Rezoning Transportation Analysis

Petition Number: #2022-057

Revision Log:

Date	Description
09-29-22	First Review (PDM)
10-27-22	Second Review (TM)

CONCEPTUAL SITE PLAN		
PETITION NUMBER 2022-057		
Old Plank Road Site		
CITY OF CHARLOTTE, NC		
NO.	DATE	REVISION
1	10/17/2022	REVISED PER STAFF COMMENTS
2	11/23/2022	REVISED PER STAFF COMMENTS
3	12/16/2022	REVISED PER STAFF COMMENTS

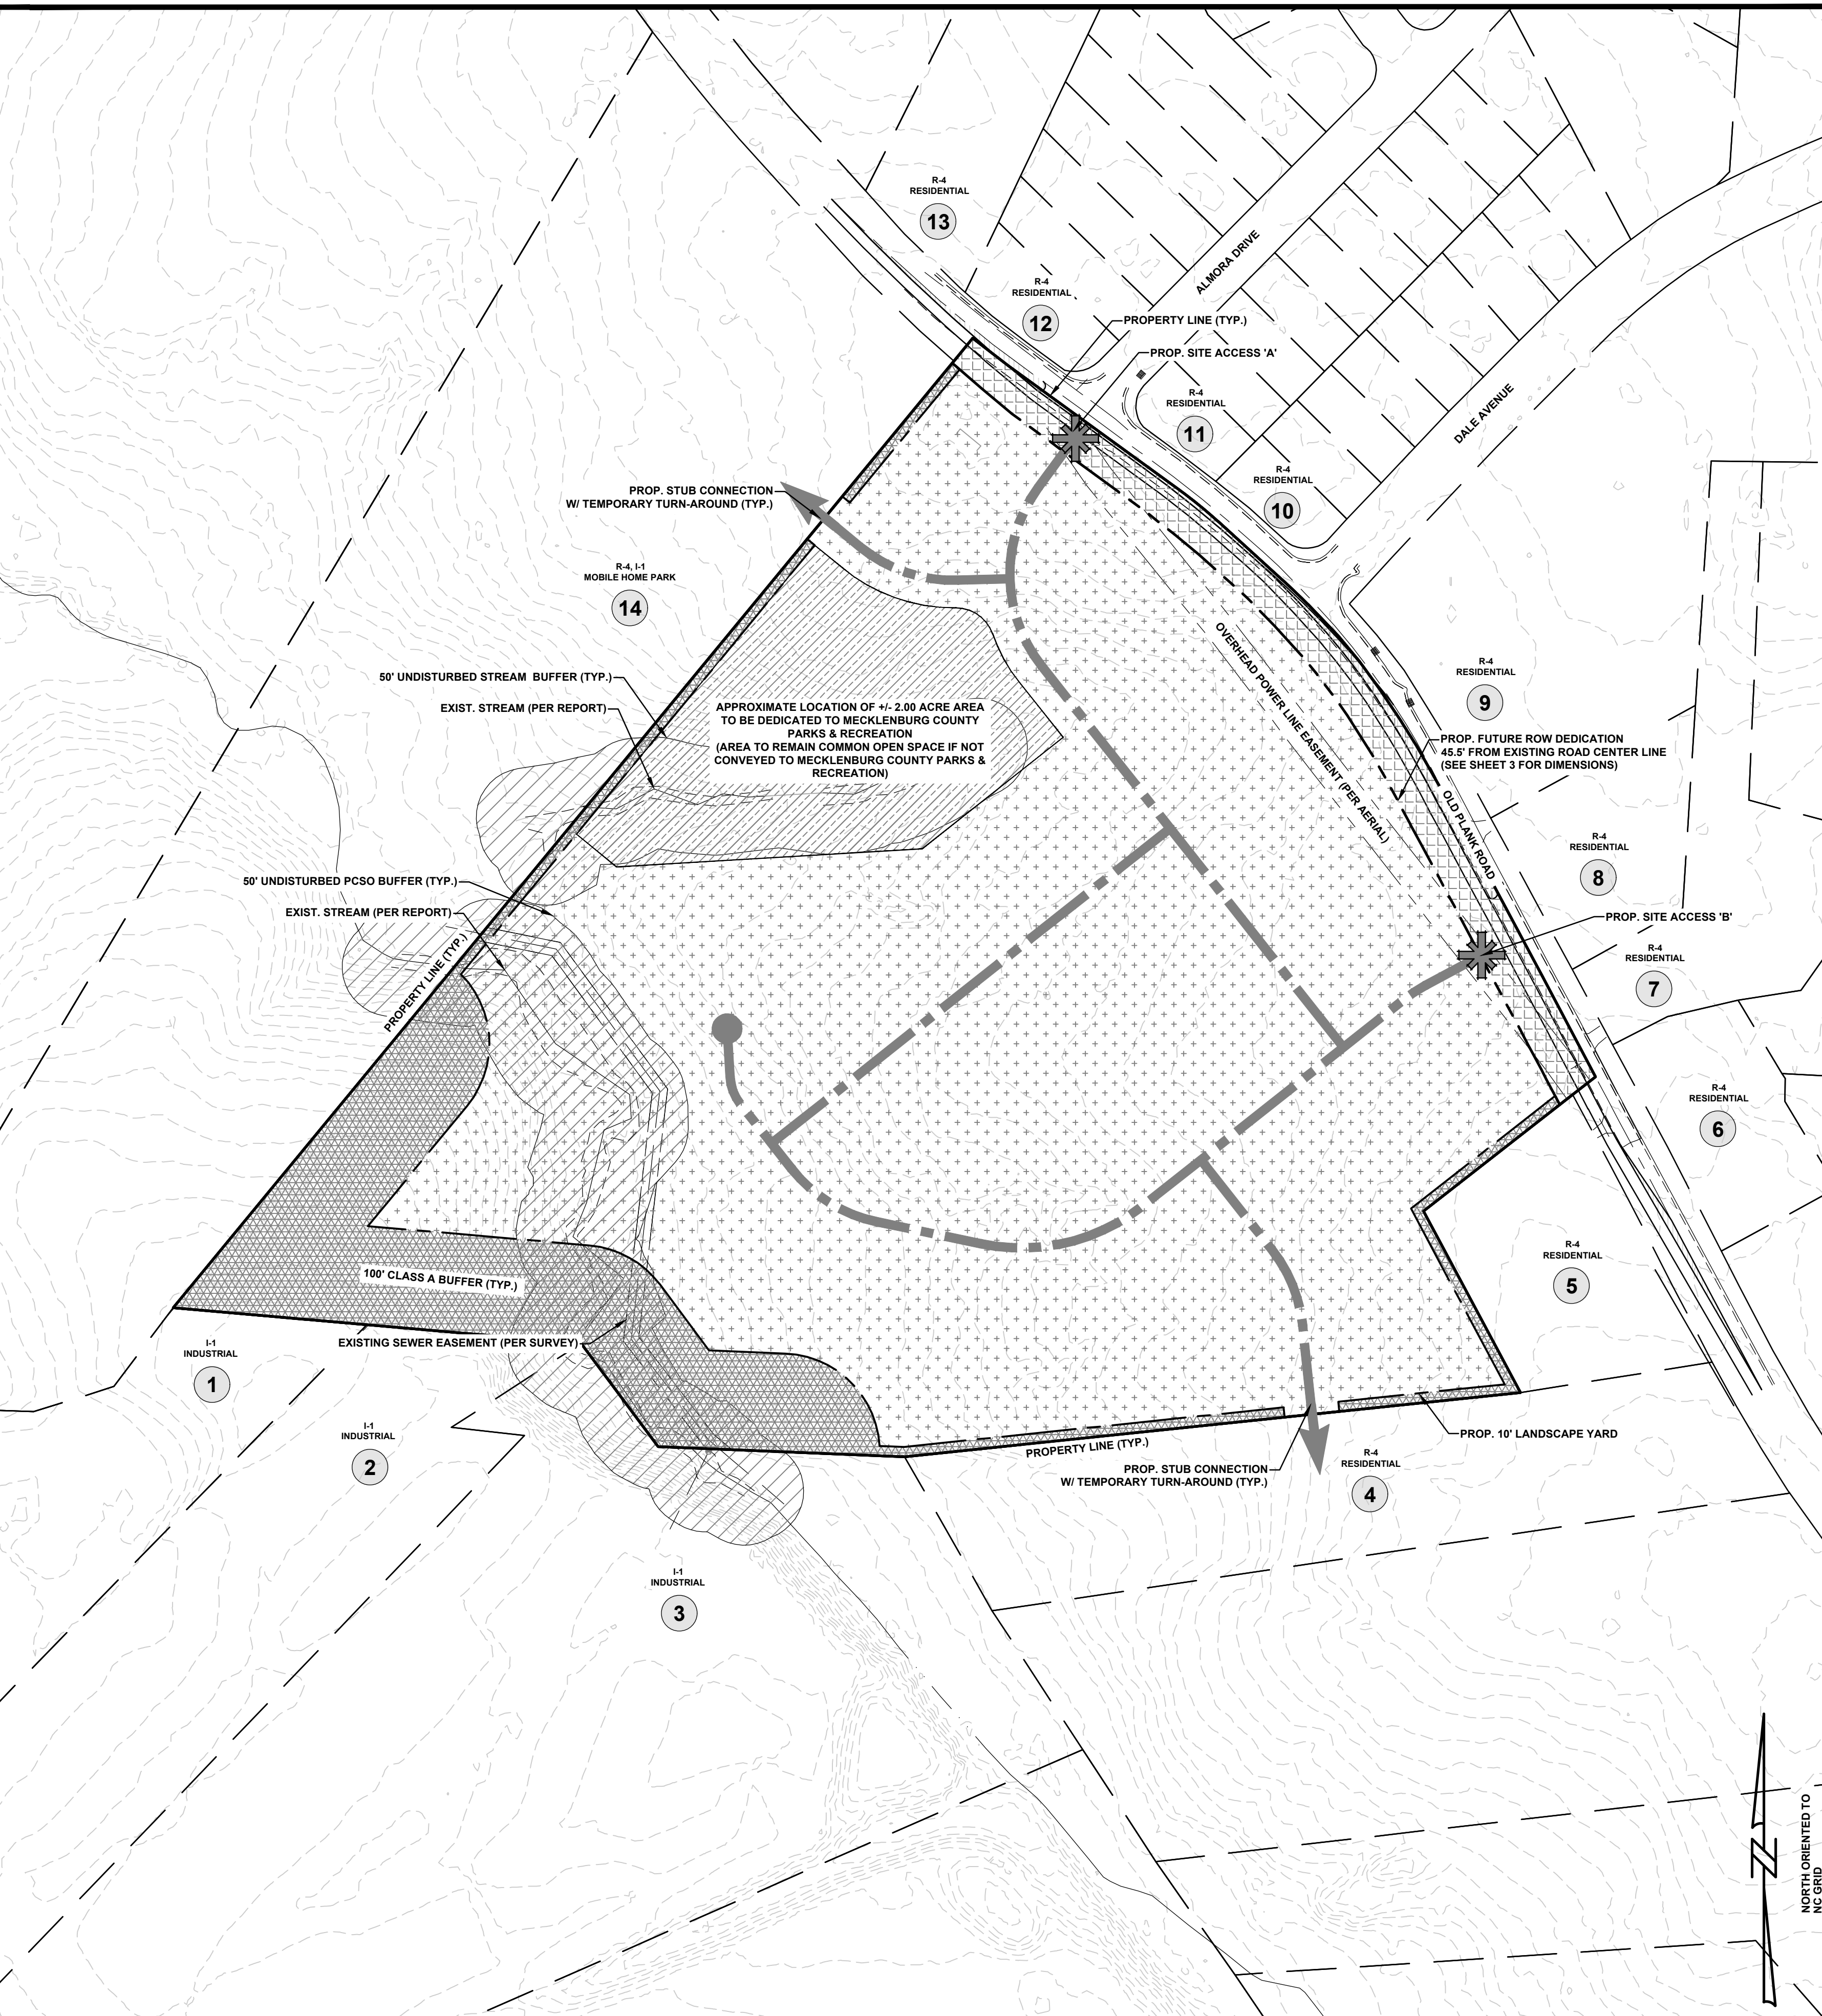
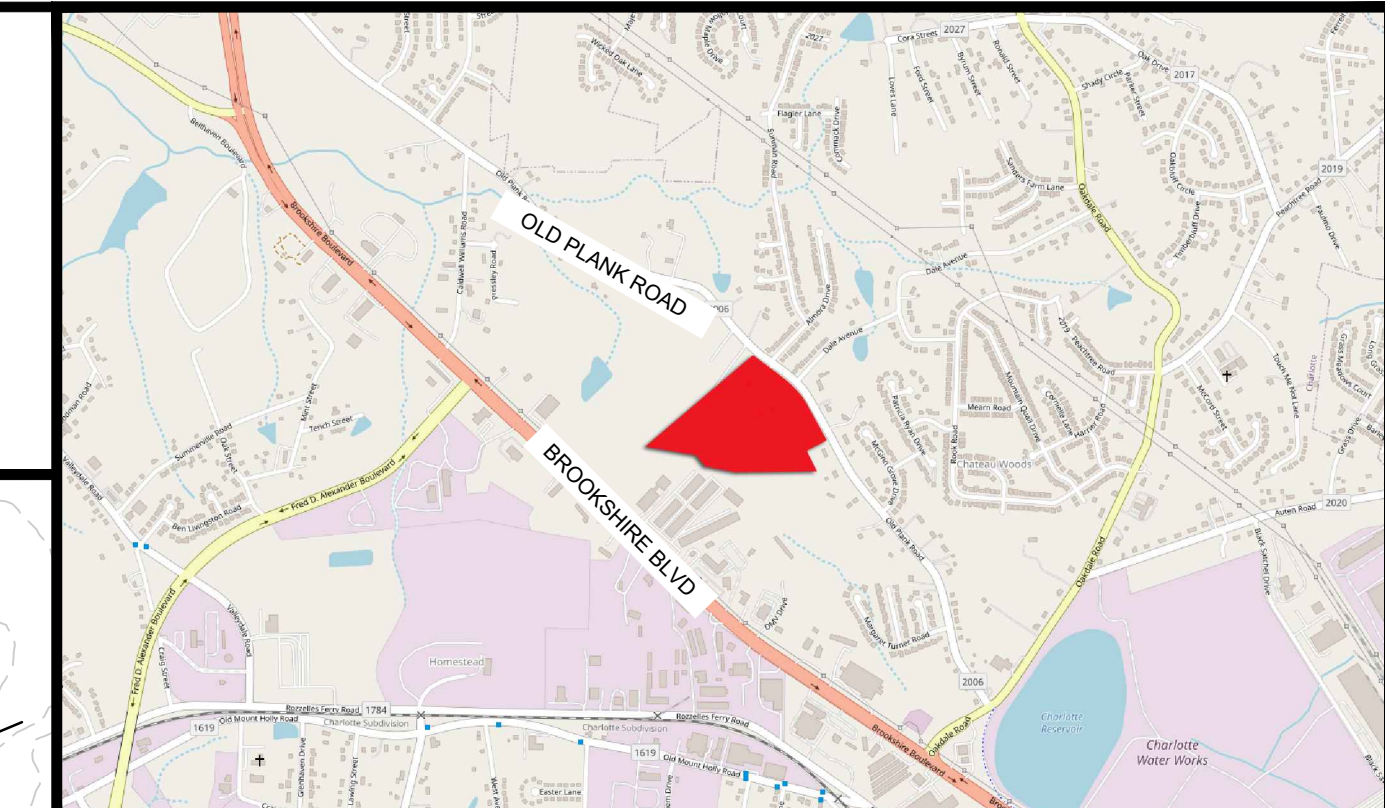
- a. ~~Old Plank Road:~~ Future location of the back of curb and gutter is 24-feet from the centerline of the roadway to the back of curb.

Outstanding Comment From 9-29-22: Label and dimension the curb and gutter from the centerline for Old Plank Road on the site plan.

5. Revise site plan and conditional note(s) to commit to construct bicycle facilities along site frontage by locating the curb and gutter 24-feet from the center line and installing a 5-foot bike lane along Old Plank Road to meet the City Charlotte BIKE Policy.

Clarifying Comment From 10-26-22: Dimension back of curb from the roadway centerline.

TECHNICAL DATA
 PETITION NUMBER 2022-057

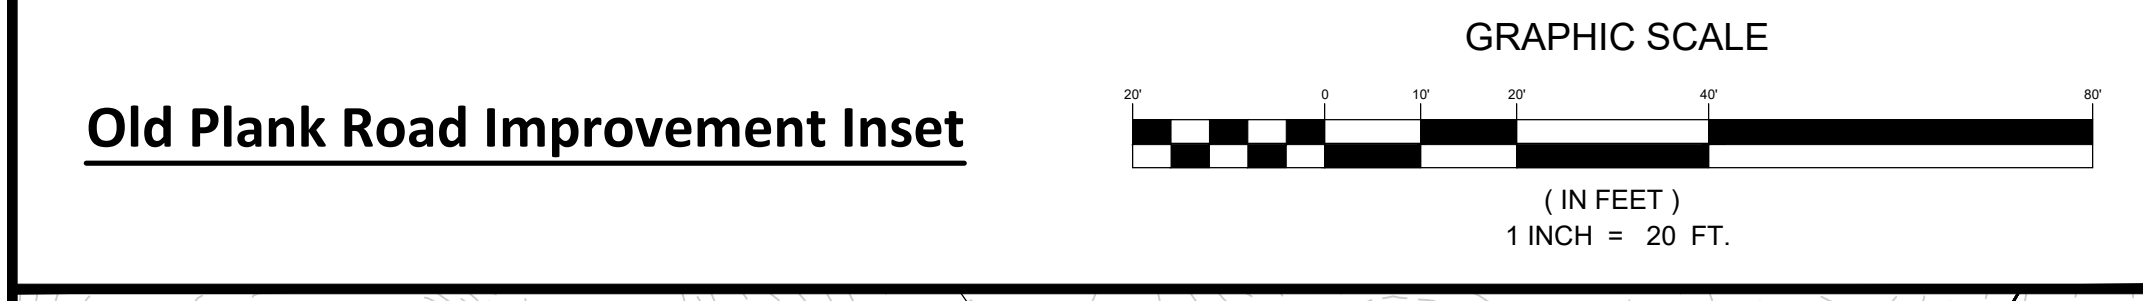
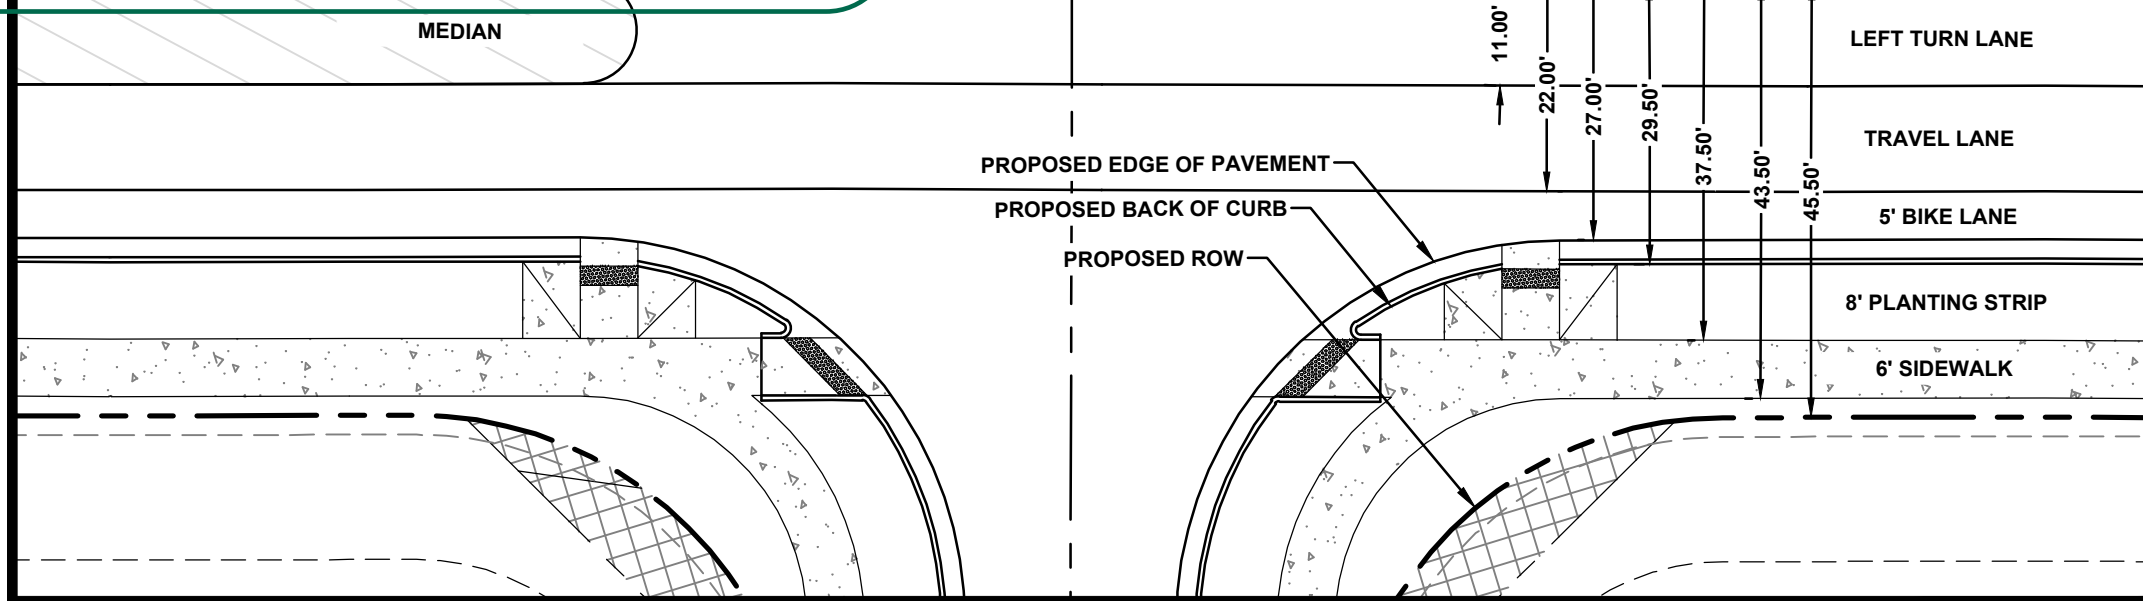
- ~~8. Revise site plan and conditional note(s) to label all roadways as public or private roadways. If the roadways will be public dimension the ROW of each road from the centerline.~~
9. Revise Transportation note 4 to include CDOT requests rights of way set at 2' behind back of sidewalk where feasible.
10. **Outstanding Comment From 9-29-22:** A site plan note specifying that all transportation improvements will be approved and constructed before the site's first building certificate of occupancy is issued as needed. The petitioner may phase transportation improvements if said improvements and phasing are explicitly described in site plan notes.

Remove Transportation Note 6 or clarify the full scope of the proposed phasing, including which improvements are proposed under each phase. Streetscape improvements to Old Plank Road, and the proposed access roads need to be constructed prior to the site's first building certificate of occupancy. The installation of the left turn lanes on Old Plank Road could be phased if desired.

Remove or clarify the proposed phasing.
